COUNTY COUNCIL'S RESPONSE TO CONSULTATION ON THE FOLLOWING DEVELOPMENT PROPOSAL

Application No: 17/02167/F

Proposal: Conversion of building from B1(a) Offices to 25 residential flats, with ancillary parking, bin storage and amenity area

Location: The Old Malthouse St Johns Road Banbury

Figure 7.0 – Proposed site plan

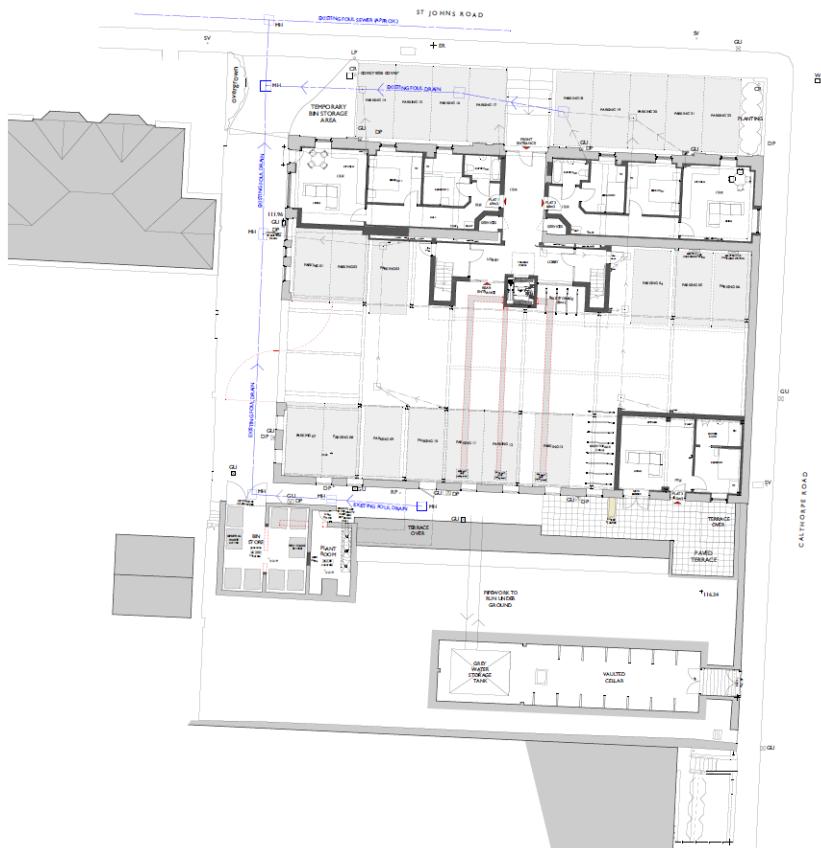
Since my response of 20 November 2017 I have been made aware of Drawing No. 17_057-200. This shows a communal refuse storage area approximately 35m south of the highway boundary along a private access road accessed through a lockable gate. They propose to have a temporary refuse collection area immediately south of the highway boundary where refuse bins will be left out for collection on the relevant day by way of a Janitor for the building being responsible for getting the bins to the collection point.

This proposed arrangement is not ideal as communal refuse bins are very large heavy objects for one person to move a distance of 35m. However, given that the building is listed it is difficult to see how a refuse storage point can be built at the front of the building near the highway. The applicant might be best advised to arrange for private refuse collection.

The applicant has stated that they will be able to provide up to 22 vehicular parking spaces within the curtilage of the site. From Drawing No. 17_057-200 it appears that they intend to provide 13 spaces in the under-croft area on the ground floor of the building and 9 spaces immediately north of the existing front entrance to the building.

Prior to the commencement of development, a plan showing the location of refuse collection facilities for the development must be submitted and approved in writing by the Local Planning Authority. Thereafter, and prior to the first occupation of the proposed development, construction shall only commence in accordance with the approved details.

Prior to the commencement of development, a plan showing all internal vehicular parking spaces which will be part of the development must be submitted and approved in writing by the Local Planning Authority. Thereafter, and prior to the first occupation of the proposed development, construction shall only commence in accordance with the approved details.
